# ONLINE CONSULTEE RESPONSE ON PLANNING APPLICATION 18/10038

Location CORRIE, KITWALLS LANE, MILFORD-ON-SEA  
SO41 0RJ

Comment Only received from NPA TREES

Drawing Title:	Location Plan
Drawing No:	LP.01
Scale:	As stated @ A3
Revision:	-
Date:	November 2020

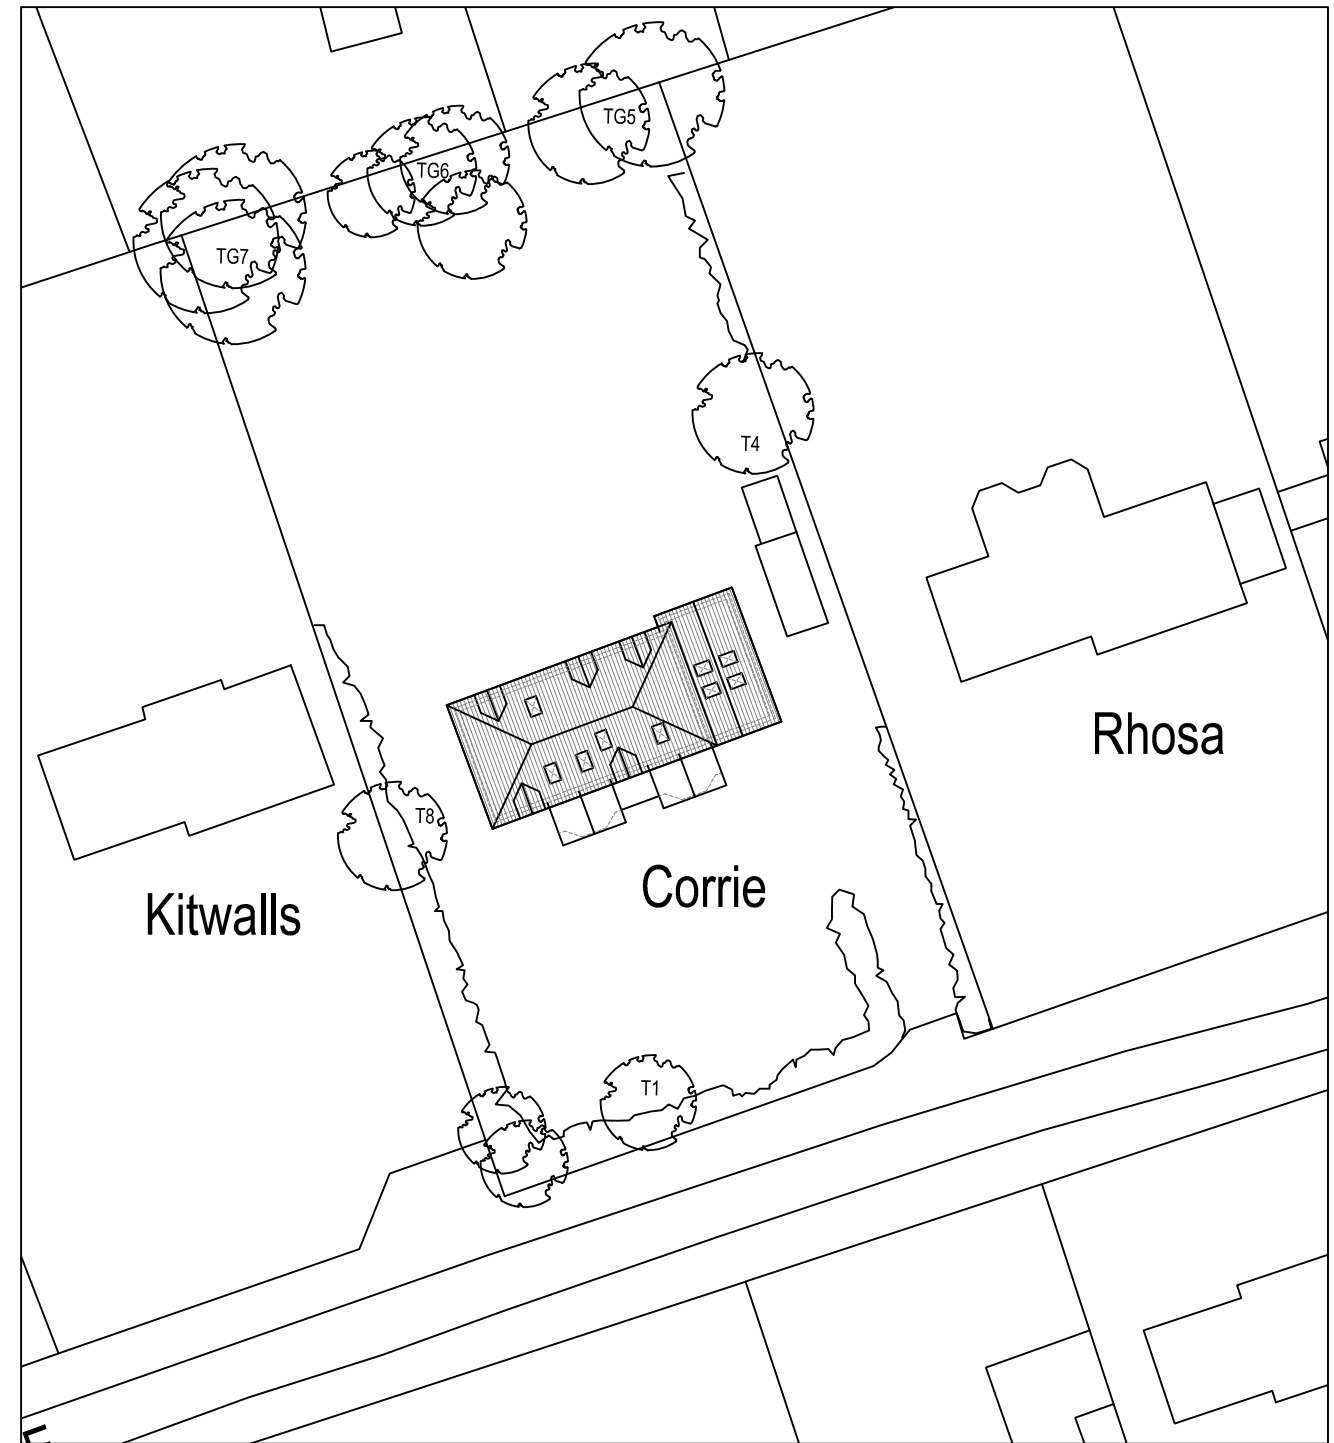
A majority of the protected trees on site are far enough away from the proposal not be affected by the extension and building modifications with the exception of Lime tree marked as T4 within the submitted site plan and marked as T28 within the TPO schedule.

The plans show the existing garage and outbuilding to be replaced with a new extension to the east. The outbuilding has been constructed on a concrete slabs that in turn will in turn reduce the roots expected to be found in this location. The proposed building does not extend as far as the existing building and should therefore improve the relationship between built structures and this tree.

Overall I do not feel that the proposed development will have a detrimental impact on the existing trees on site, however robust Tree Protection fencing should be specified and illustrated on a plan to be installed prior to the commencement of works.

No development, demolition or site clearance shall take place until the following information has been provided:

Tree protection Plan in accordance with BS5837: 2012 and timing of events e.g. fencing to be installed prior to the commencement of works and remain in situ for the duration of the development;

and approved in writing by the Local Planning Authority. Development shall only take place in accordance with these approved details.
